Inspector's Report ABP-321519-24

Development	Construction of dwelling house, installation of waste water treatment system, and for all associated site works
Location	Dromsullivan South, Bantry, Co. Cork
Planning Authority	West Cork County Council
Planning Authority Reg. Ref.	24500
Applicant(s)	Shauna O'Sullivan
Type of Application	Permission
Planning Authority Decision	Grant with conditions
Type of Appeal	Third Party
Appellant(s)	Eugene O'Sullivan
Observer(s)	none
Date of Site Inspection	12 th June 2025
Inspector	Aisling MacNamara

Figure 2.3 Groundwater flow and location of features on the site

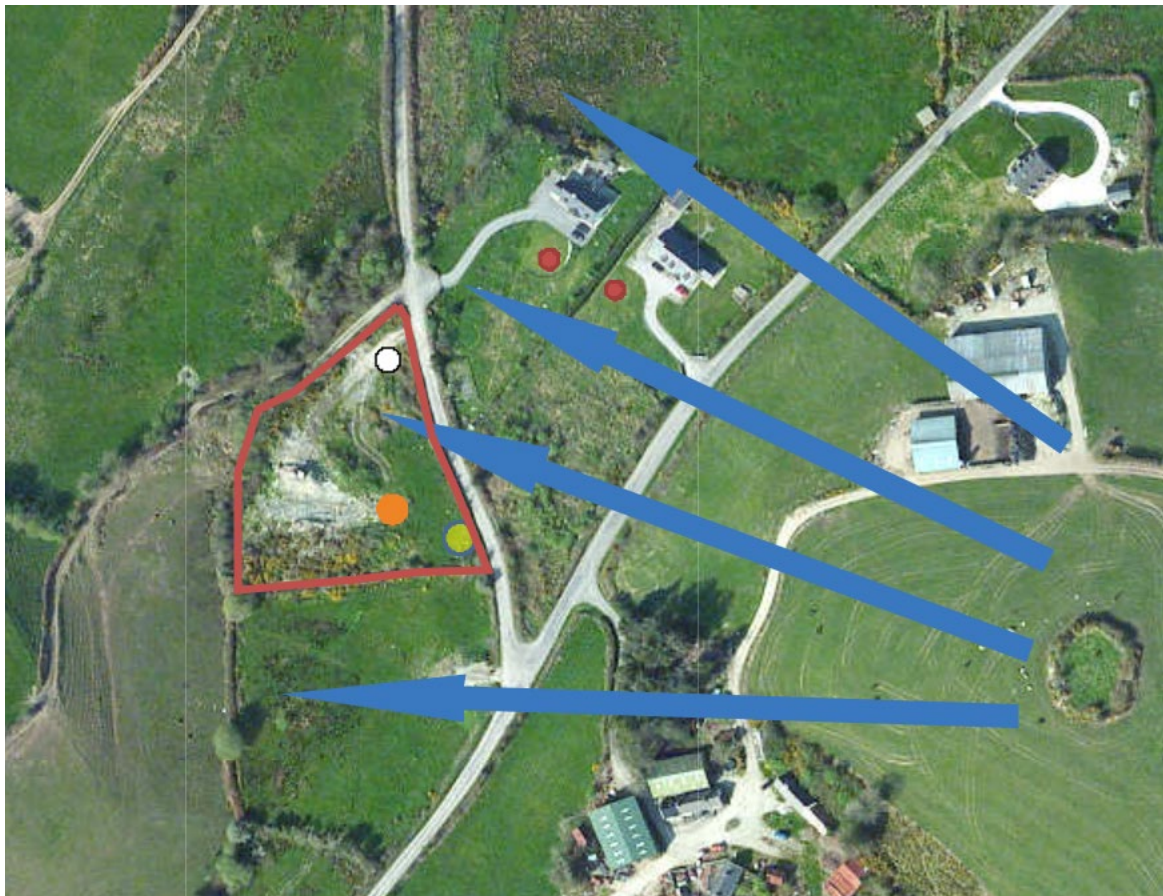
- 8.4.7. The minimum separation distances outlined in Table 6.2 of the CoP can be achieved for all identified features which relate to the site. Existing neighbouring wells to the east are 118m and 114m upgradient of the WWTS. The required 15m minimum separation distance is achieved.

- 8.4.8. Table 6.2 identifies that soakaway for surface water drainage should be located down gradient of the infiltration treatment area. In this case, it is proposed to install the soakaway upgradient of the infiltration treatment area. Should permission be

- 8.5.3. The Institute of Geologists of Ireland guidance document 'Water Well Construction' sets out recommended distance of a private well from a pollution source. Depending on the type of subsoil, minimum distances range from 30m to 60m. The proposed well is to be 55m and 70m from the existing septic tanks and percolation areas to the east. I am satisfied that the proposed well is located a satisfactory distance from nearby waste water treatment systems and that the proposed well would not be at risk from this source of contamination.

granted, a condition should be attached requiring the relocation of the soakaway downgradient of the infiltration treatment area.
